WEST SUSSEX COUNTY COUNCIL CONSULTATION

TO:	Arun District Council - FAO: Amber Willard
FROM:	WSCC – Highways Authority
DATE:	28 September 2026
LOCATION:	Paynters Croft Burndell Road Arundel BN18 0HR
SUBJECT:	F/36/26/OUT Outline planning application with some matters reserved (except for access and layout) for the erection of 40 No dwellings with vehicular access from Burndell Road, provision of associated open space, alongside landscaping, drainage infrastructure and associated works. This application is a Departure from the Development Plan. Response to highways and drainage comments.
DATE OF SITE VISIT:	Area known to officer
RECOMMENDATION:	No Objection

Drawing Status	Planning		
Client	Edge BP		
Project	Burndell Road, Yapton		
Drawing Title	Site Overview		
Scale	Date	Drawn by	Checked by
1:1000	May 26	EMH	EJD
Drawing No.	2025-6804-000		Rev.
			B

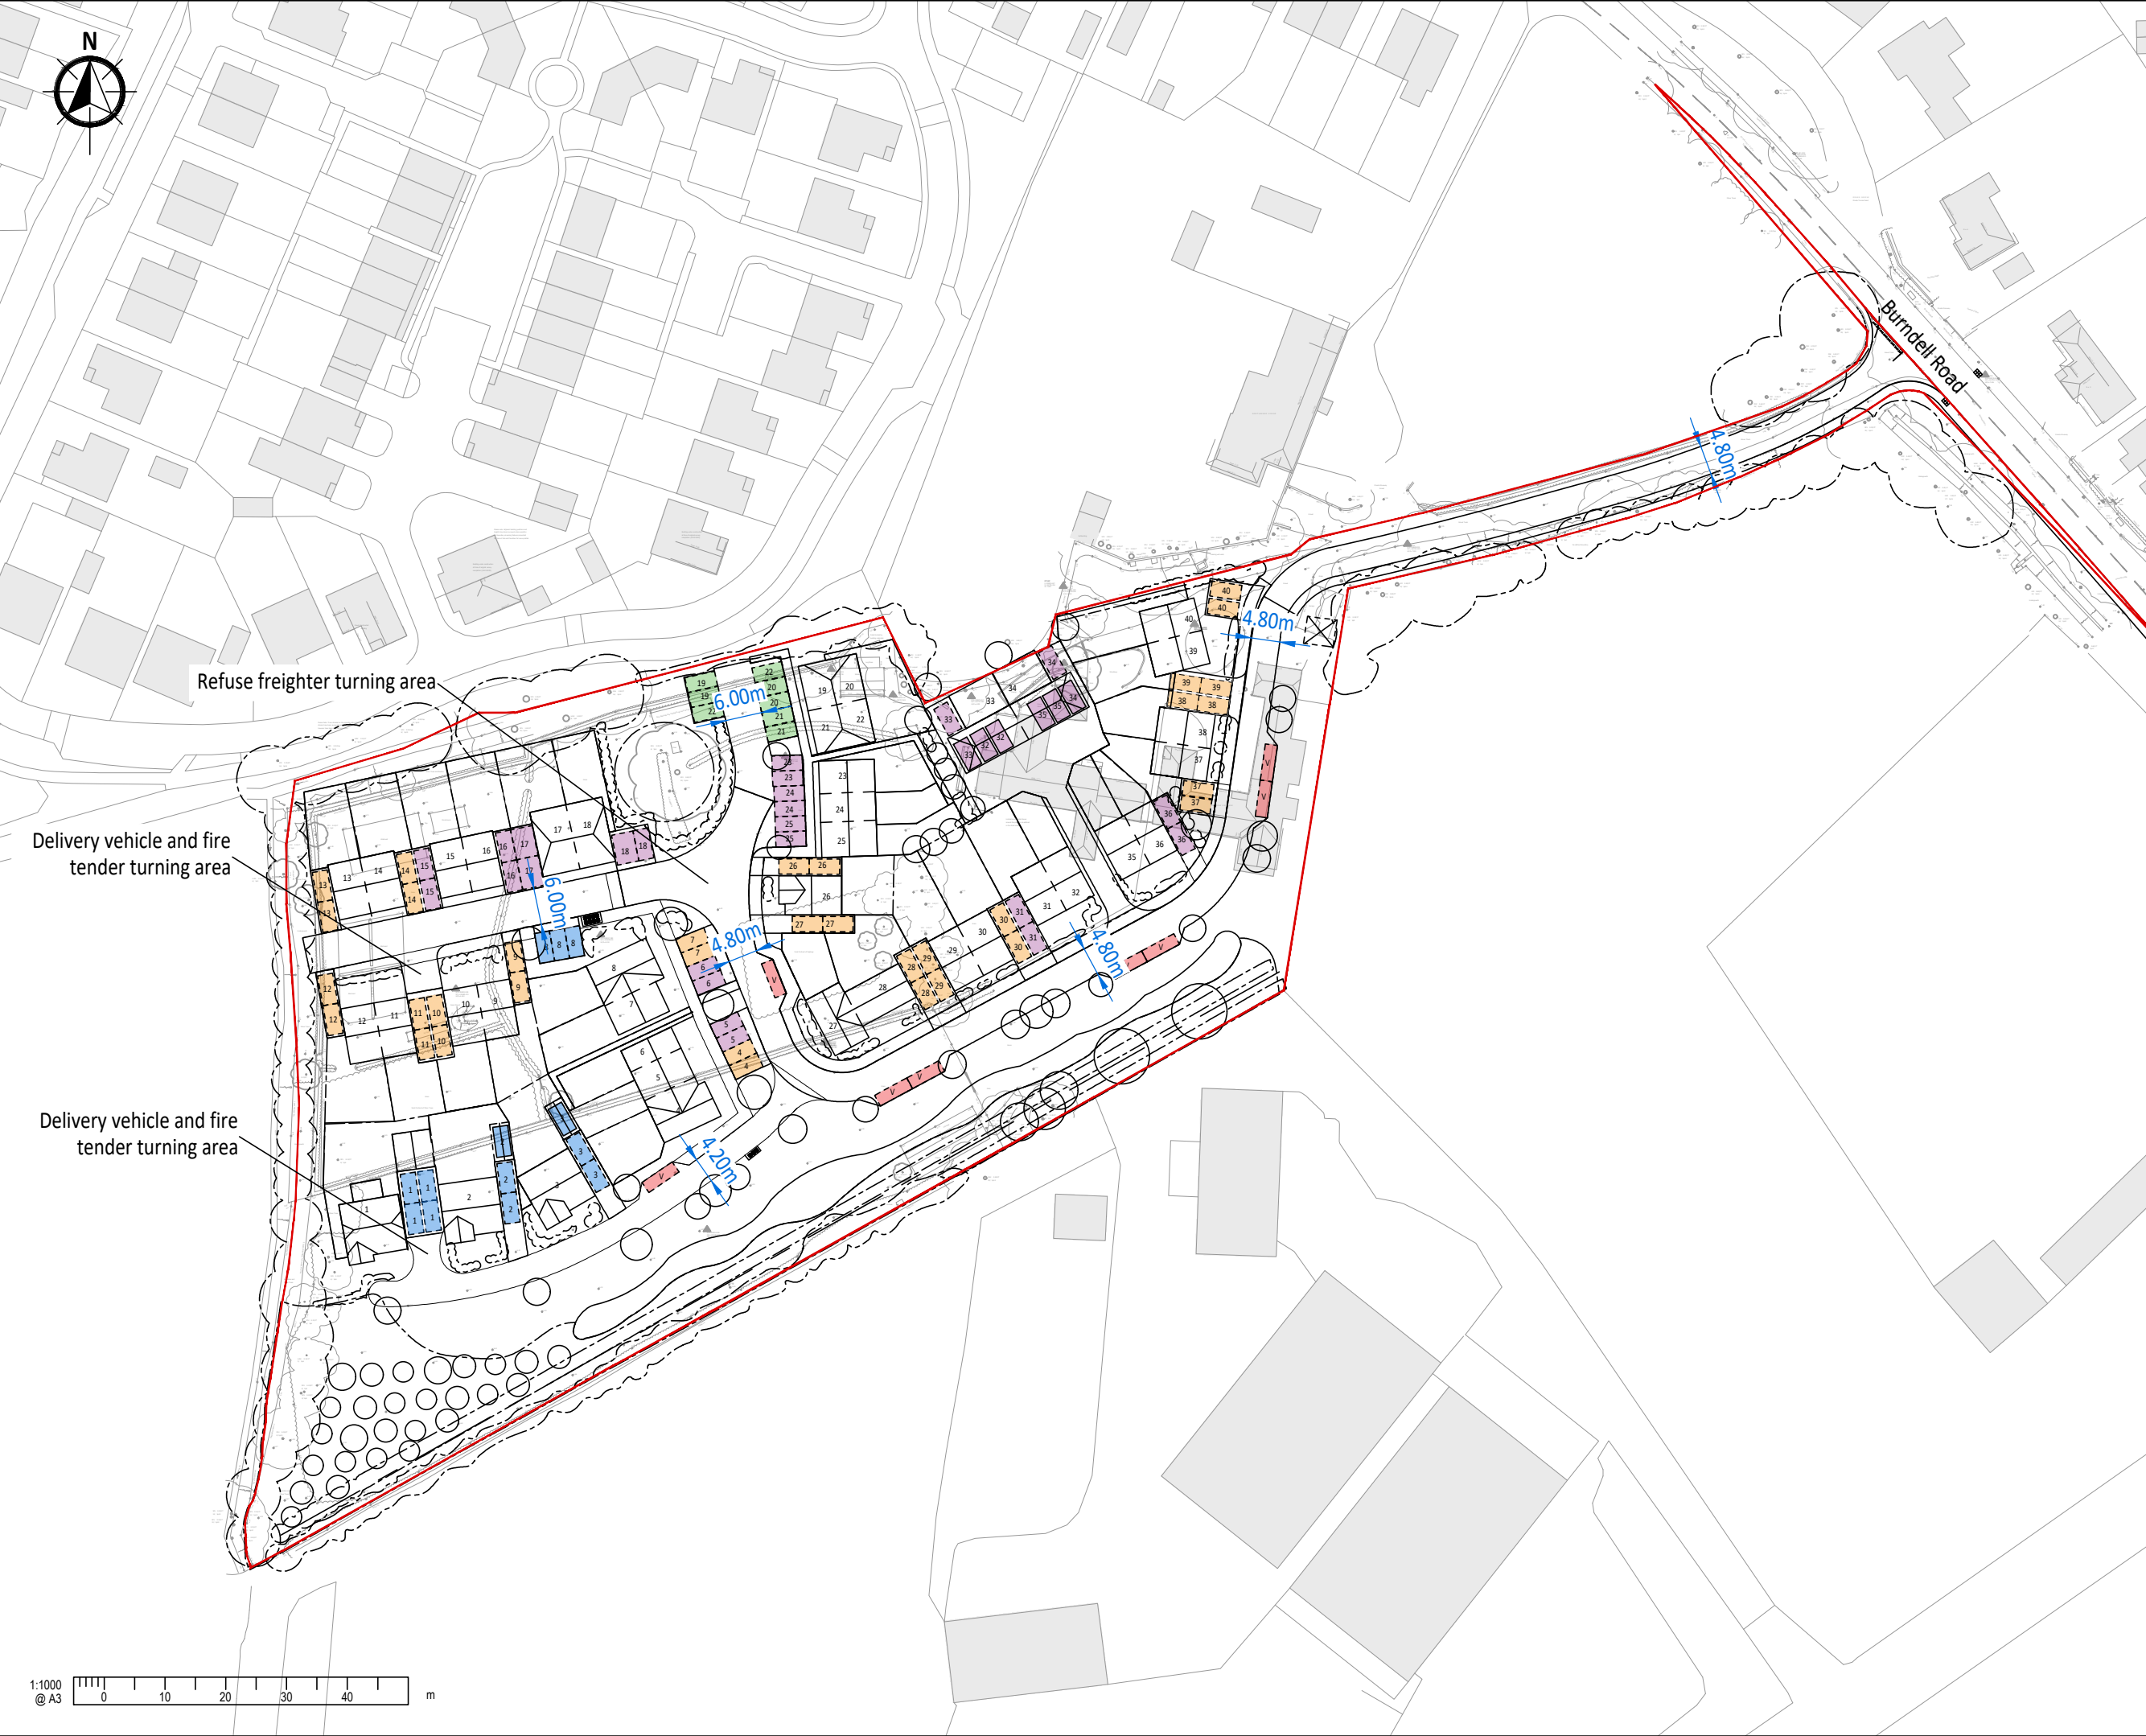
• Clarification/ plan of linking footway from site access to south Rollaston Park northbound bus stop (western side Burndell Road).

The Site Overview drawing shows a footway link to Rollaston Park Bus Stop (northbound). This would be provided as part of the access/off-site highway works under s278 agreement.

No part of the development shall be first occupied until such time as the vehicular access, footway and uncontrolled crossing, serving the development has been constructed in accordance with the details shown on the drawings titled Site Overview (2025-6804-000 Rev C), and Access Overview & Visibility Splays (2025-6804-001 Rev C).

Drawing Status	Planning		
Client	Edge BP		
Project	Burndell Road, Yapton		
Drawing Title	Access Overview & Visibility Splays		
Scale	Date	Drawn by	Checked by
1:250	May 26	EMH	EJD
Drawing No.	2025-6804-001		Rev.
			C

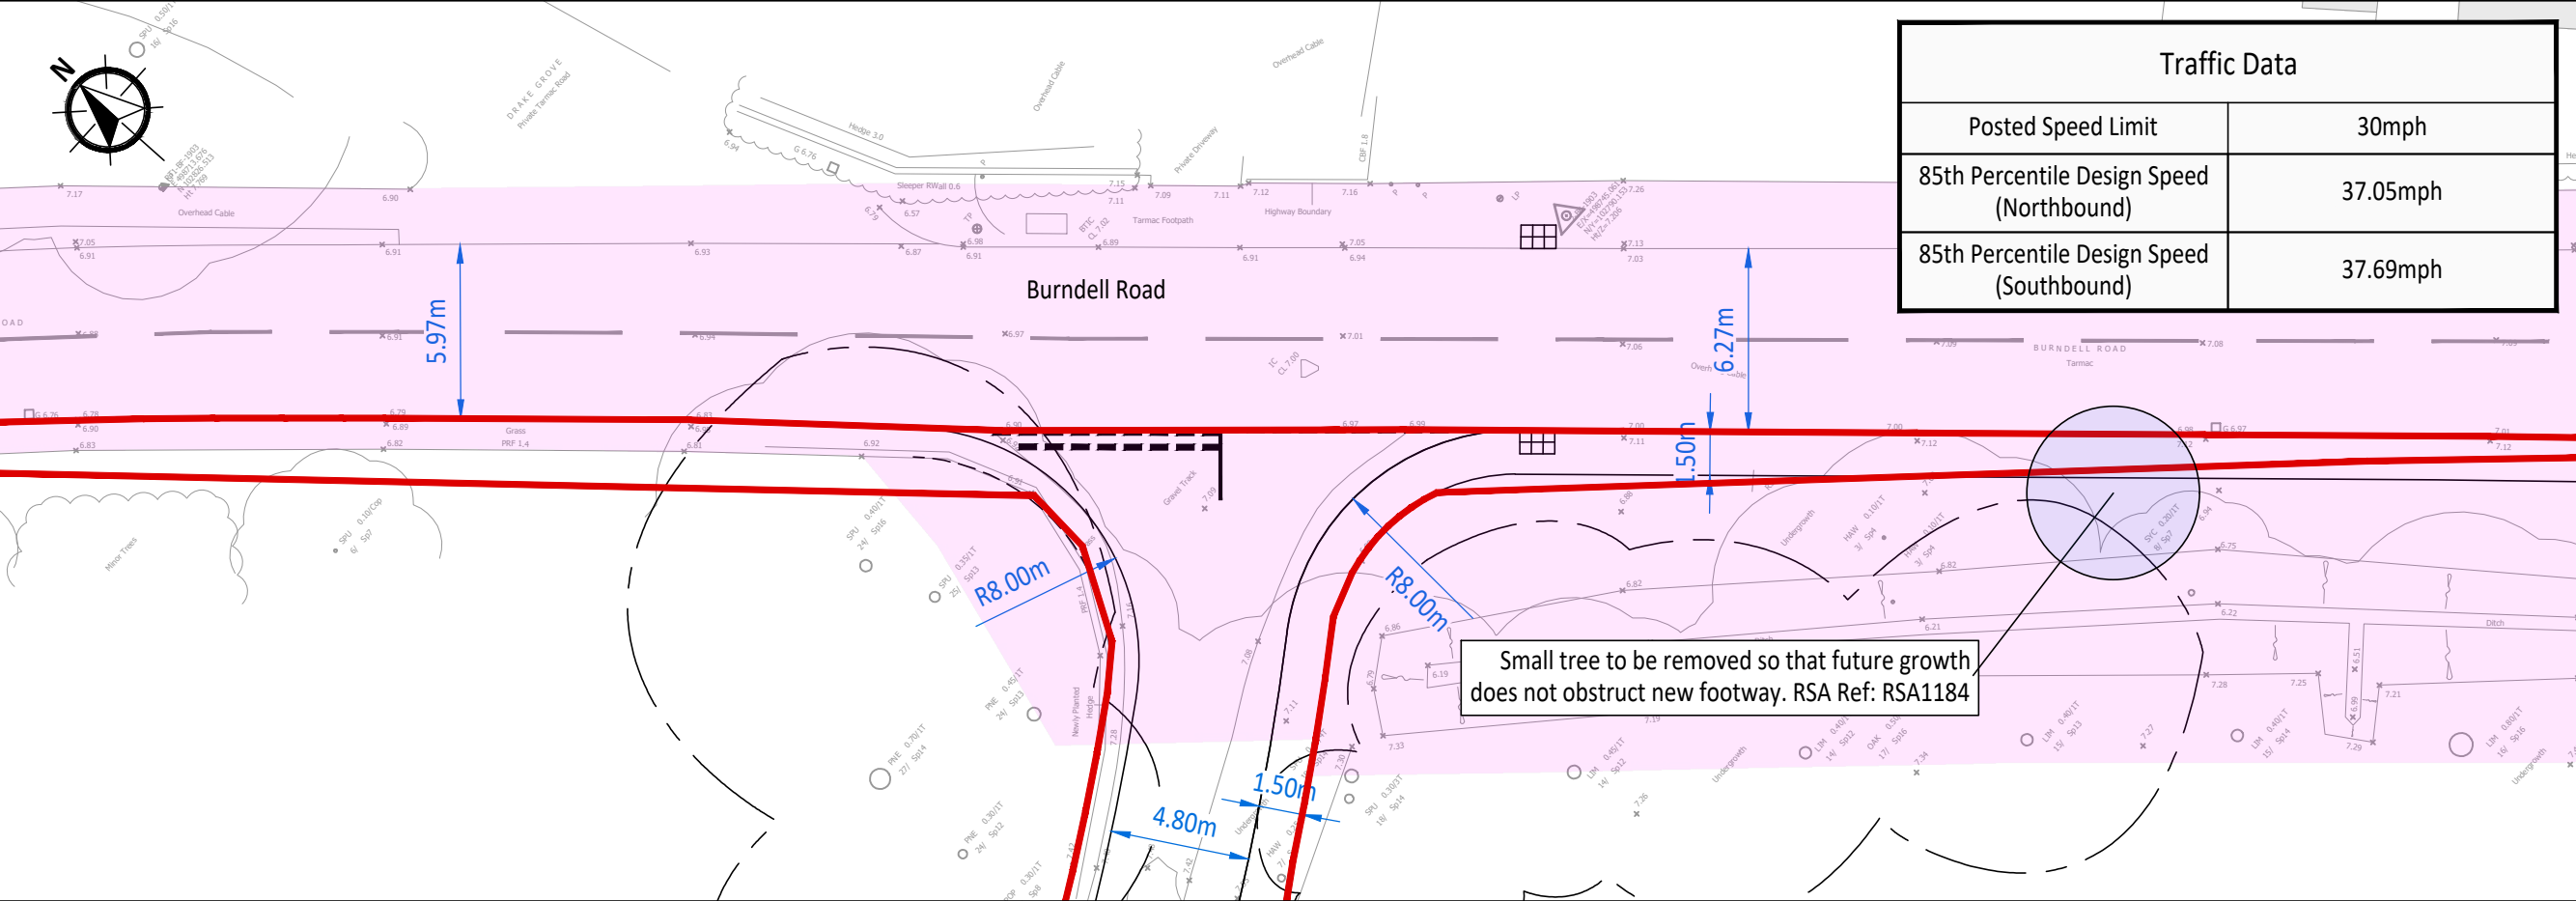
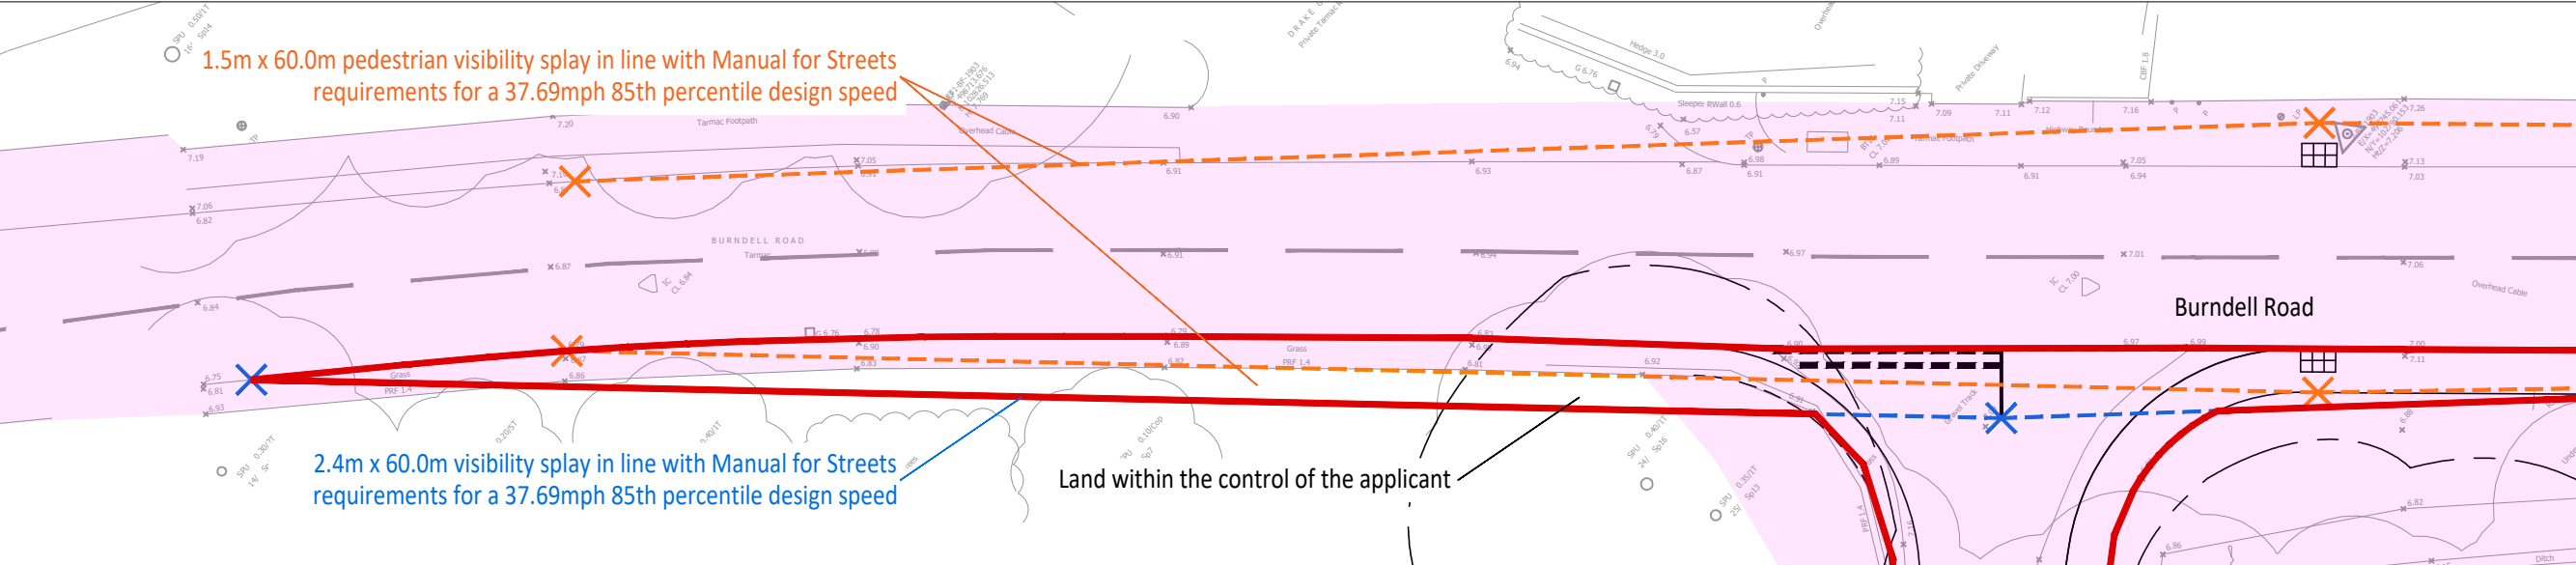
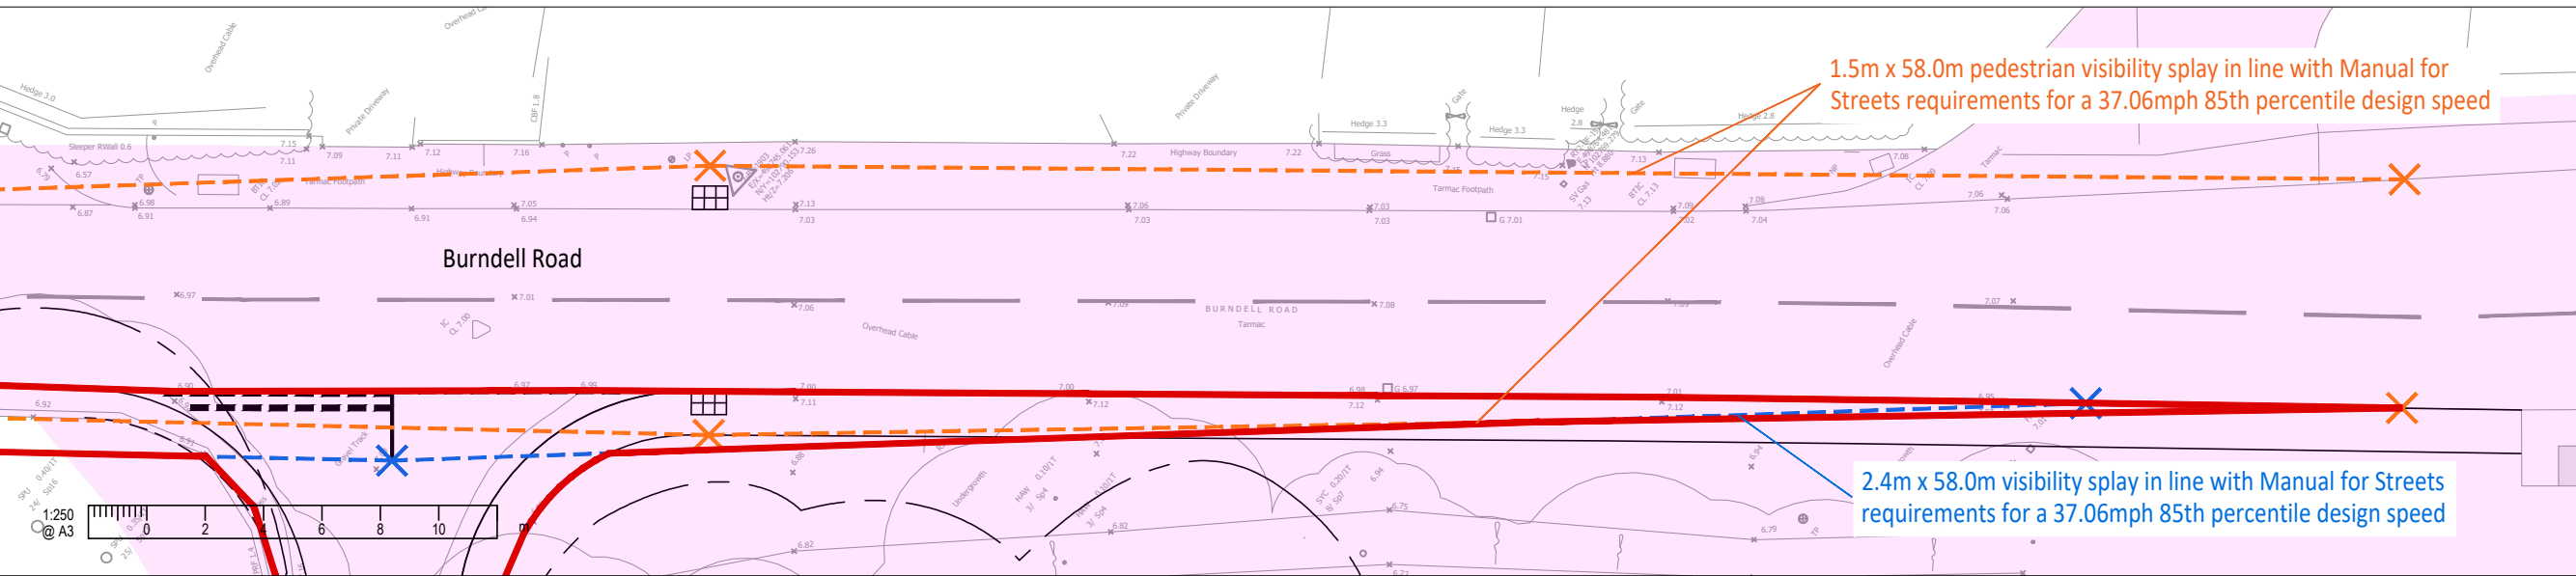
• Amended vehicular and pedestrian visibility splays (2.4m x 60m south and 62m north/ 1.5m x 60m south and 62m north)

The 85th percentile speeds were recorded as 37.9mph northbound and 38.5mph southbound (from ATC survey) which would require visibility splay of 60m south and 62m north. The applicant states these have been amended and provided but 'Access Overview & Visibility Splays' drawing 2025-6804-001 rev C still shows 60m north and 58m south. It is evident there is sufficient highway boundary and applicant land to extend these slightly and this can be secured by condition.

No part of the development shall be first occupied until vehicular and pedestrian visibility splays of 2.4 metres by 60m south and 2.4m by 62m north have been provided at the proposed site vehicular access and pedestrian crossing points onto Burndell Road in accordance with plans and details to be submitted to and approved in writing by the Local Planning Authority. Once provided the splays shall thereafter be maintained and kept free of all obstructions over a height of 0.6 metre above adjoining carriageway level or as otherwise agreed.
